Department for Transport

Date: 3 November 2020

Application by Highways England ("the Applicant") for an Order granting Development Consent to construct a replacement of three roundabouts on the A38 in Derby known as the Kingsway, Markeaton and Little Eaton junctions with grade-separated interchanges. ("the Proposed Development").

REQUEST FOR COMMENTS FROM THE APPLICANT, NETWORK RAIL, EAST MIDLANDS RESERVE FORCES AND CADETS ASSOCIATION, WESTERN POWER DISTRIBUTION, AND OTHER INTERESTED PARTIES

Drawing Title
**LAND PLANS
REGULATION 5(2)(i)
SHEET 3 OF 10**

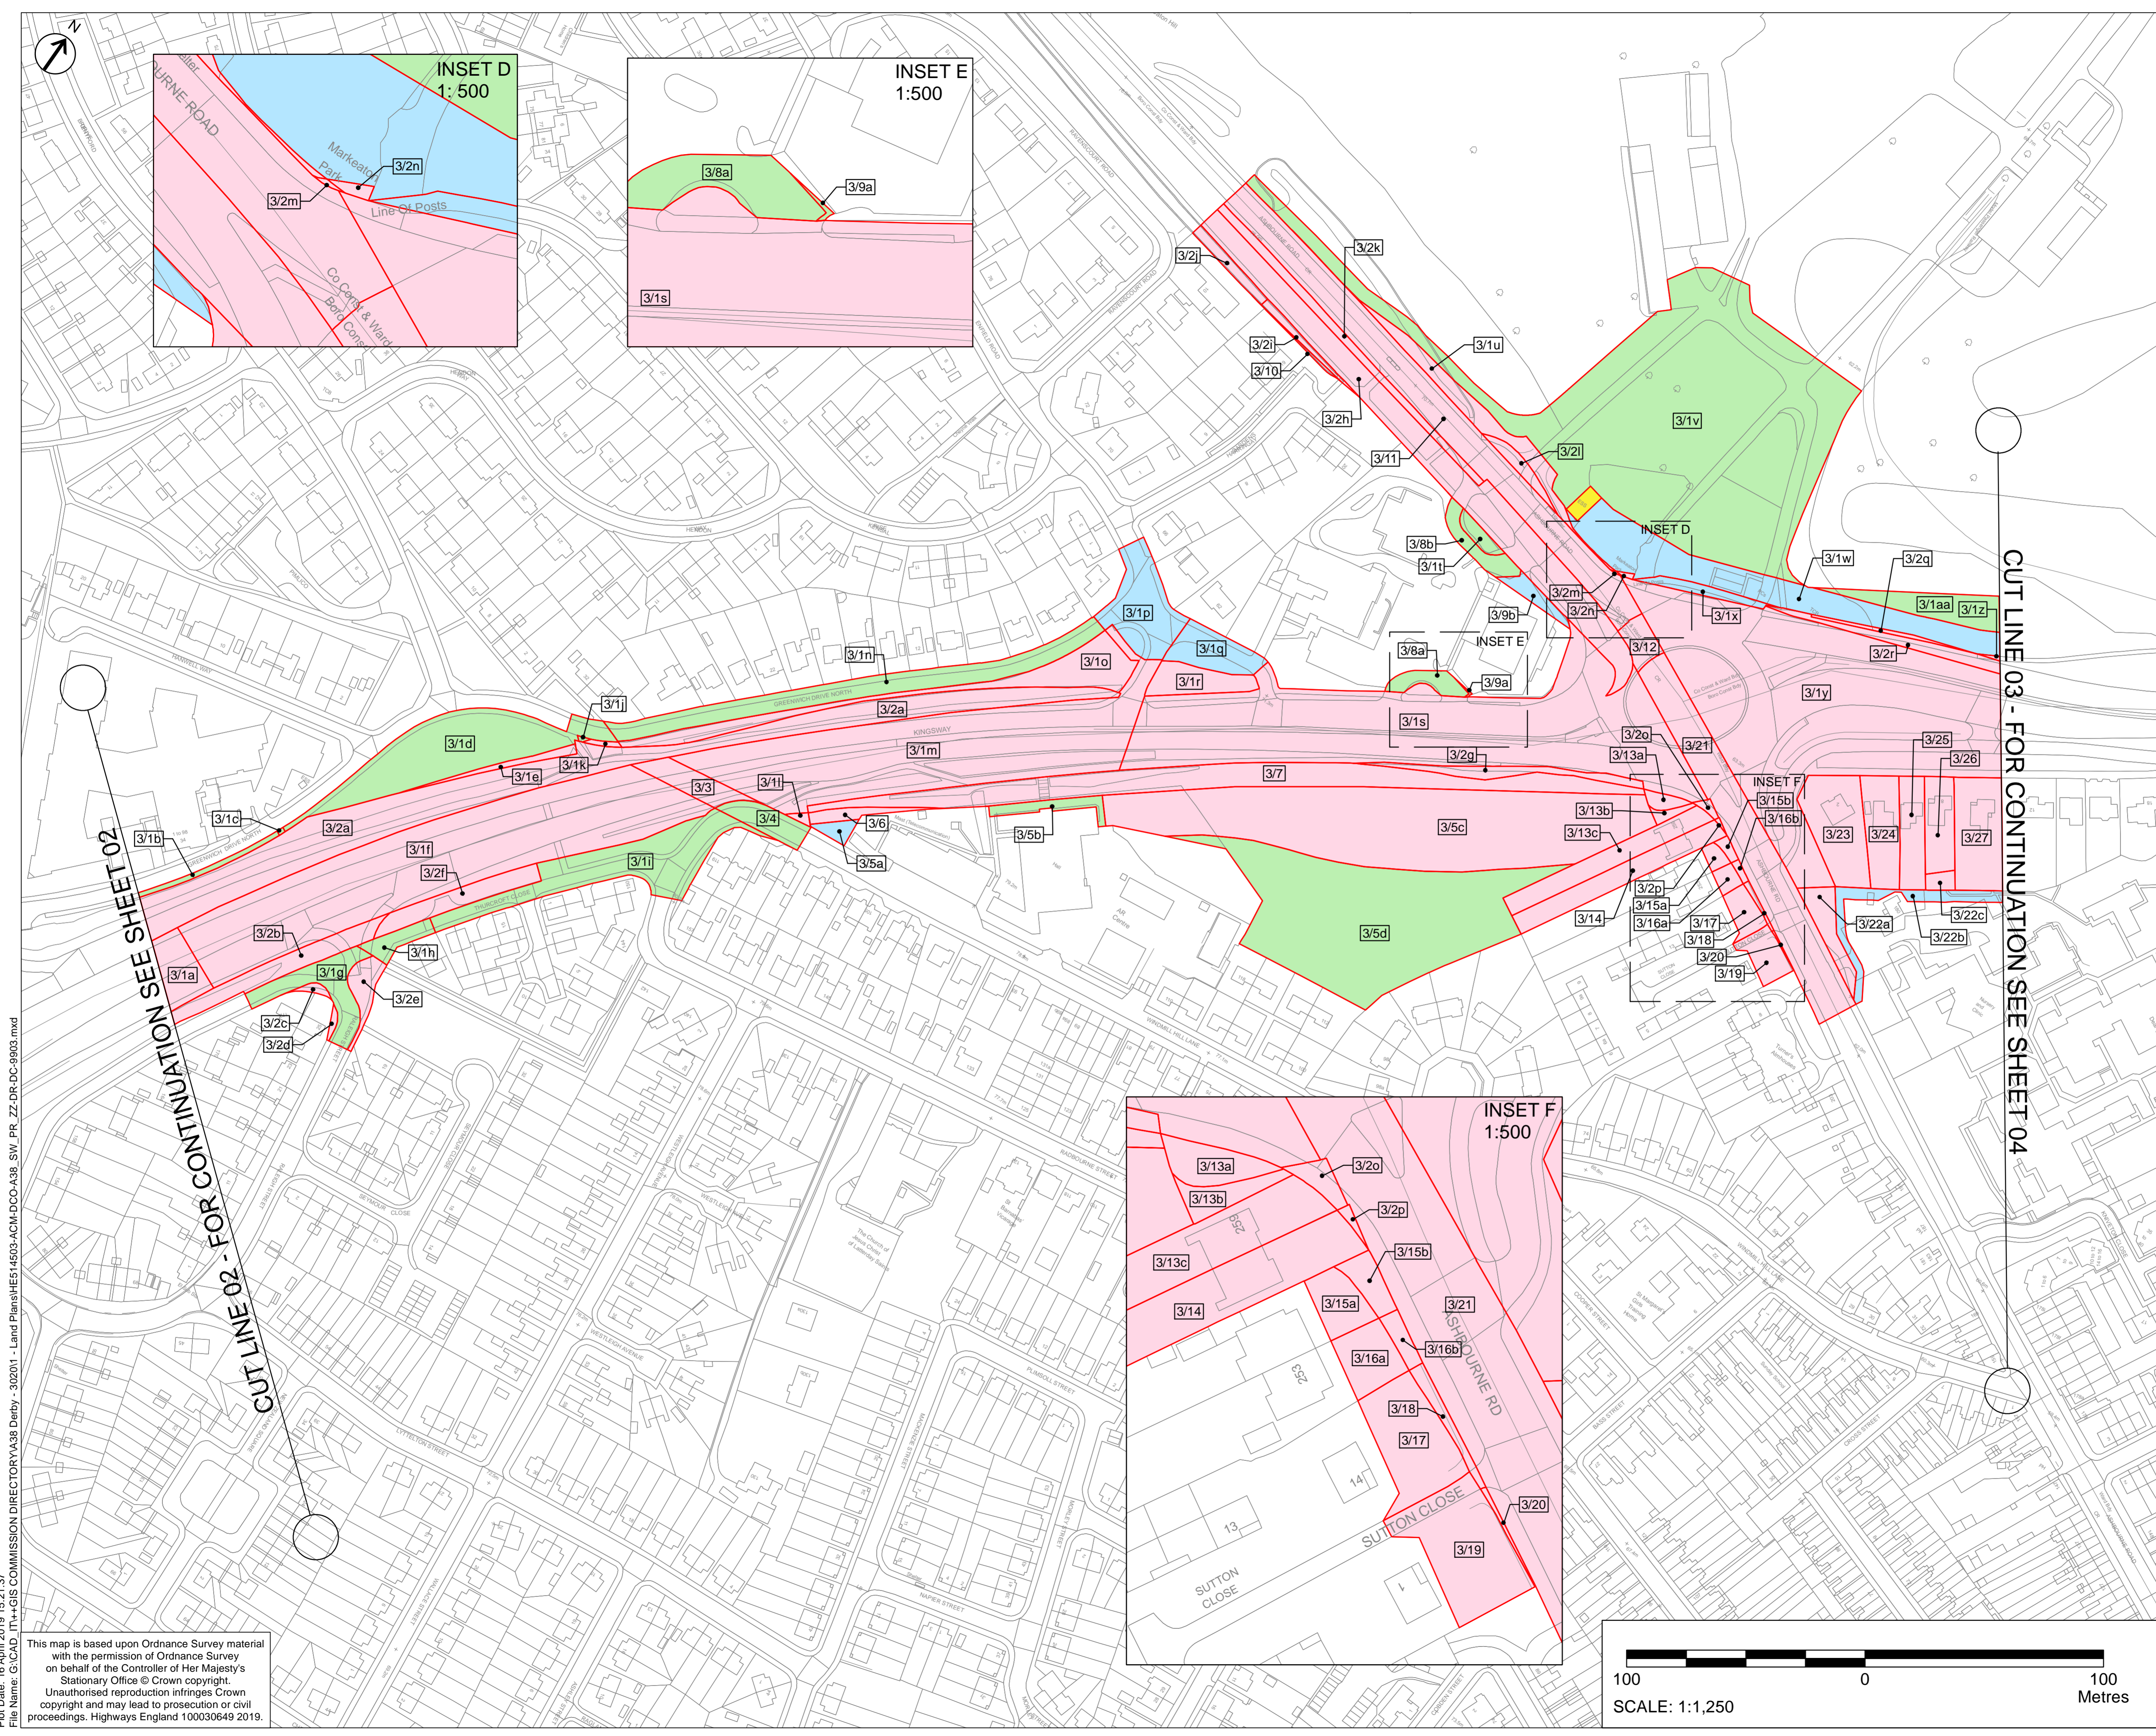
Plot 3/1aa is included in the definition of “the special category land” in article 38(5) of the DCO. The plot is described in the book of reference as “Temporary possession and use of land and acquisition of rights over land” but is shown on the land plans and special category land plans as land which is only required temporarily (and is not subject to permanent rights). The Applicant is asked to clarify whether the correctness of the description of plot 3/1aa in the book of reference.

**LAND PLANS
REGULATION 5(2)(i)
SHEET 4 OF 10**

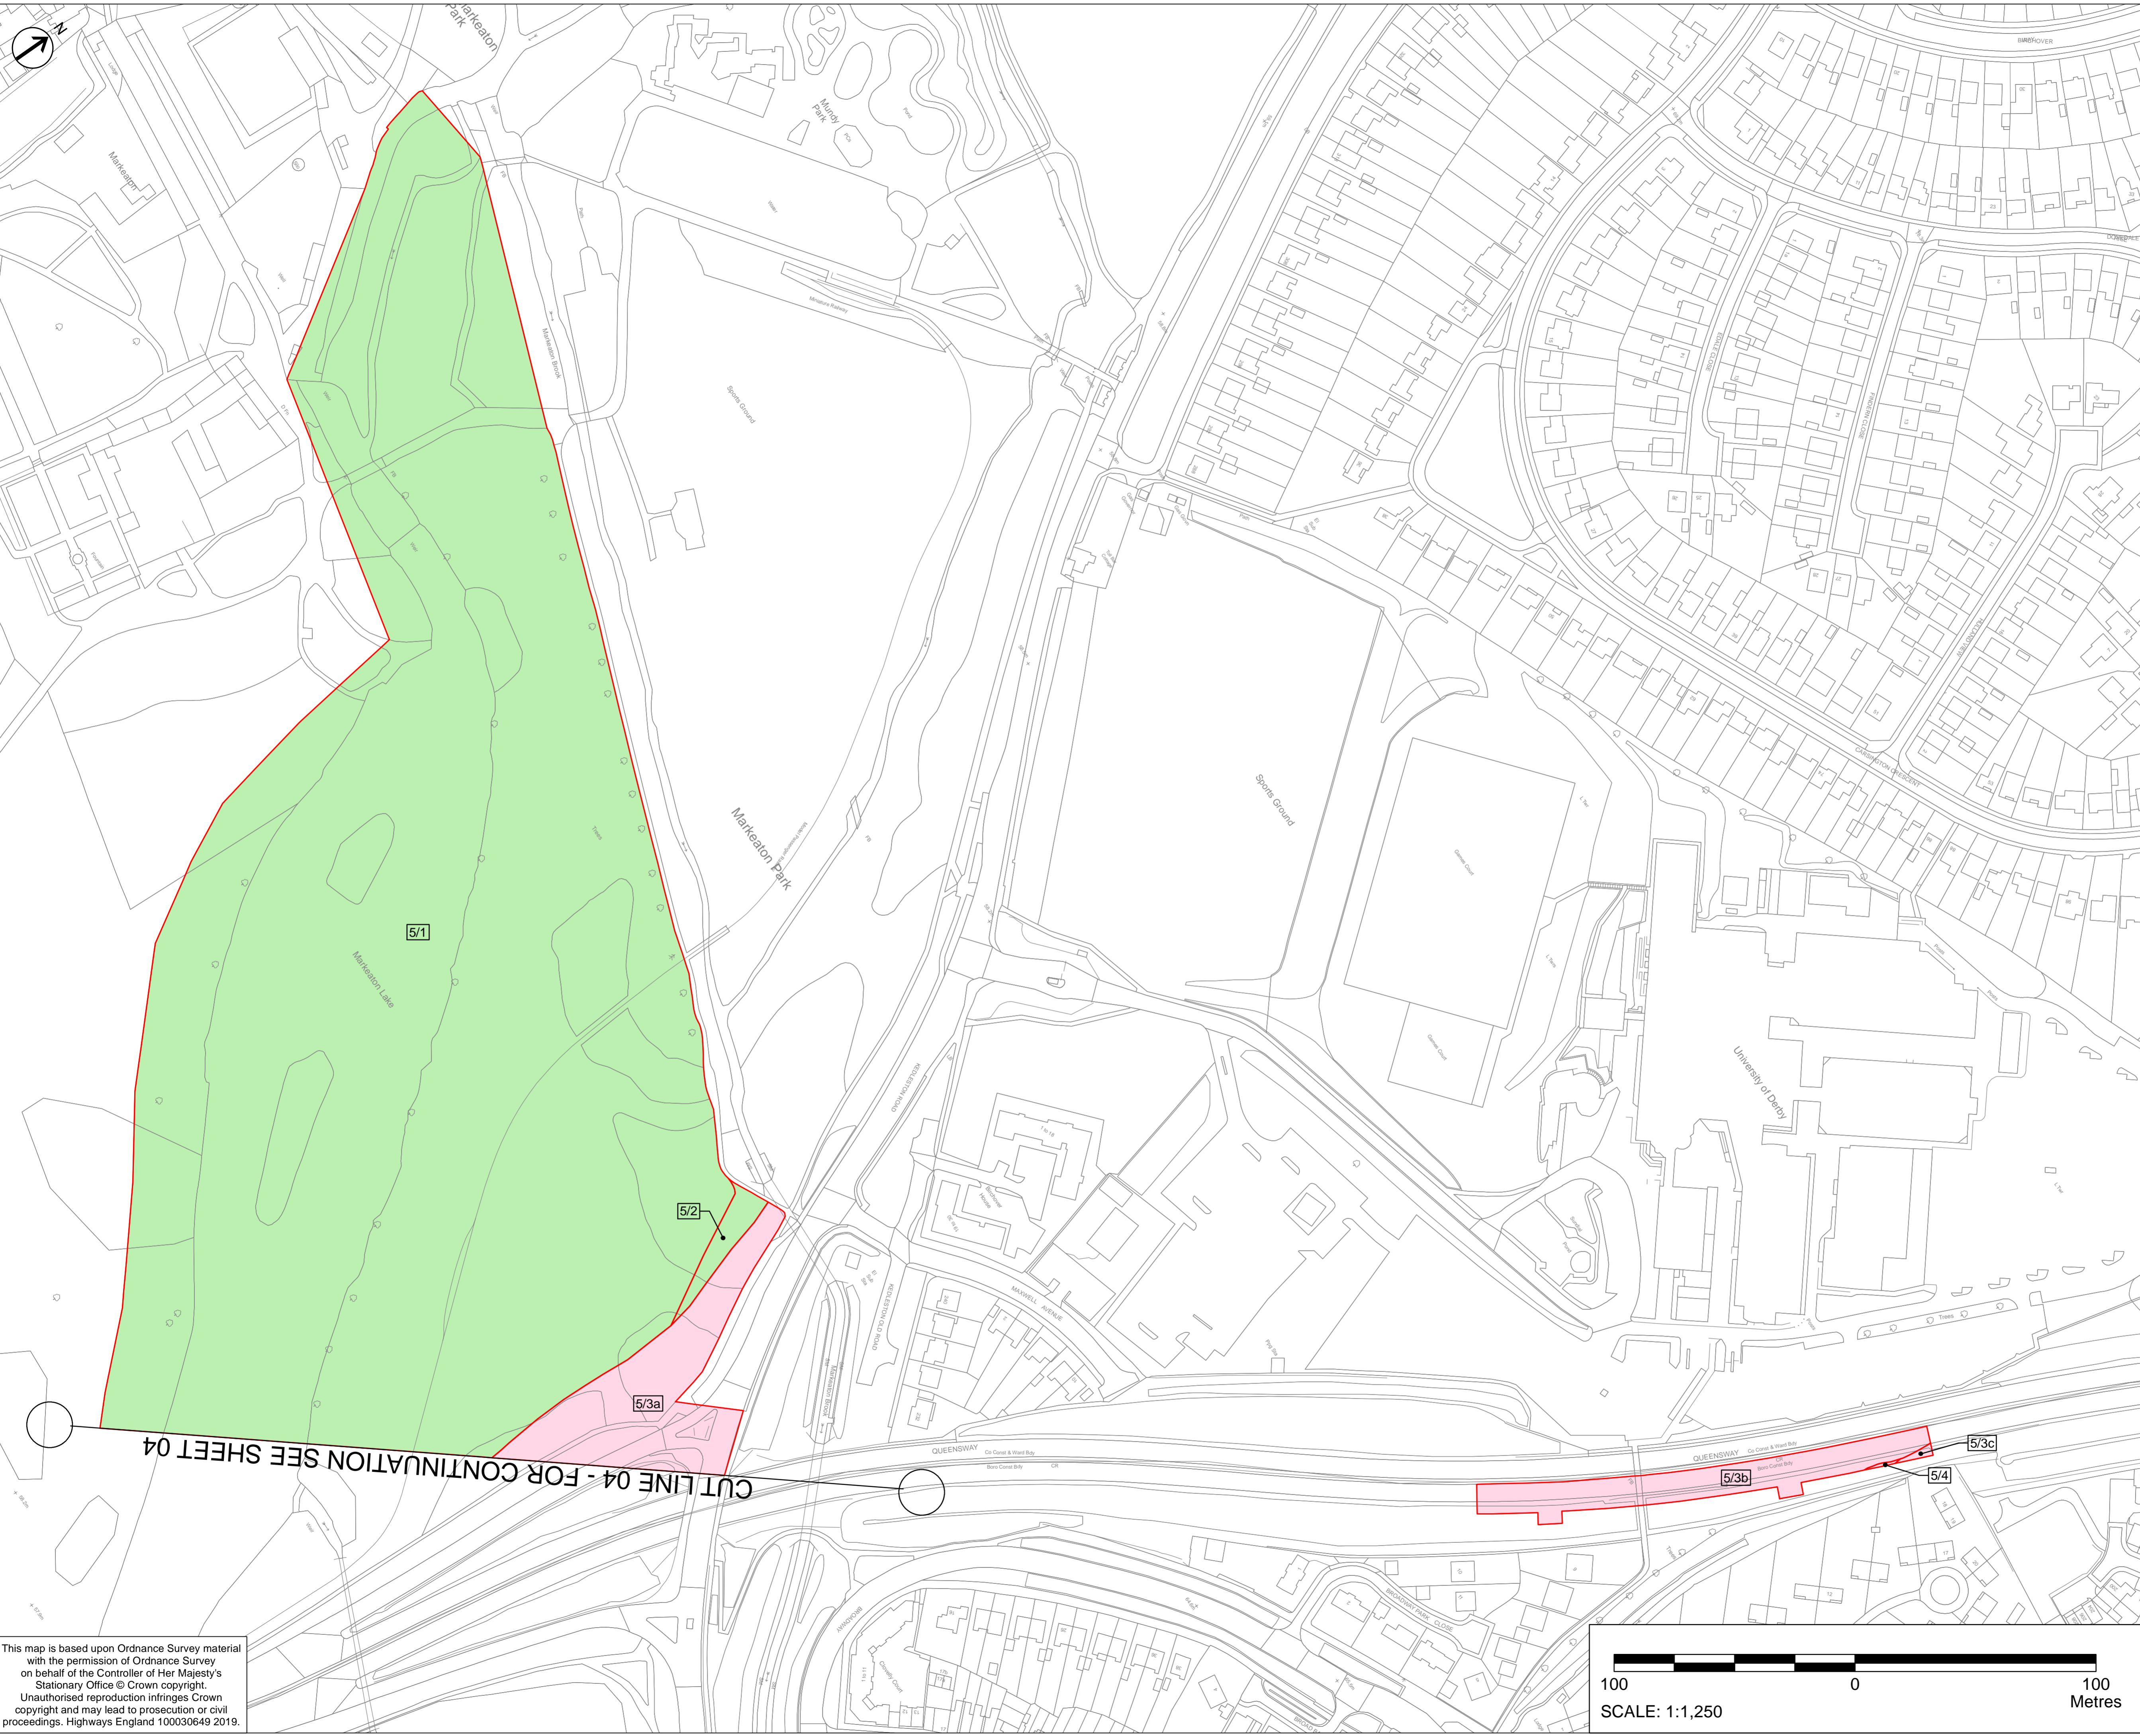
Plots 4/2f, 4/2i, 4/2k, 4/2l are not listed in the book of reference as replacement land and on the plans they do not appear to be shown as replacement land. But they are listed as replacement land (and also as special category land) in the DCO. The Applicant is asked to confirm the status of these plots of land.
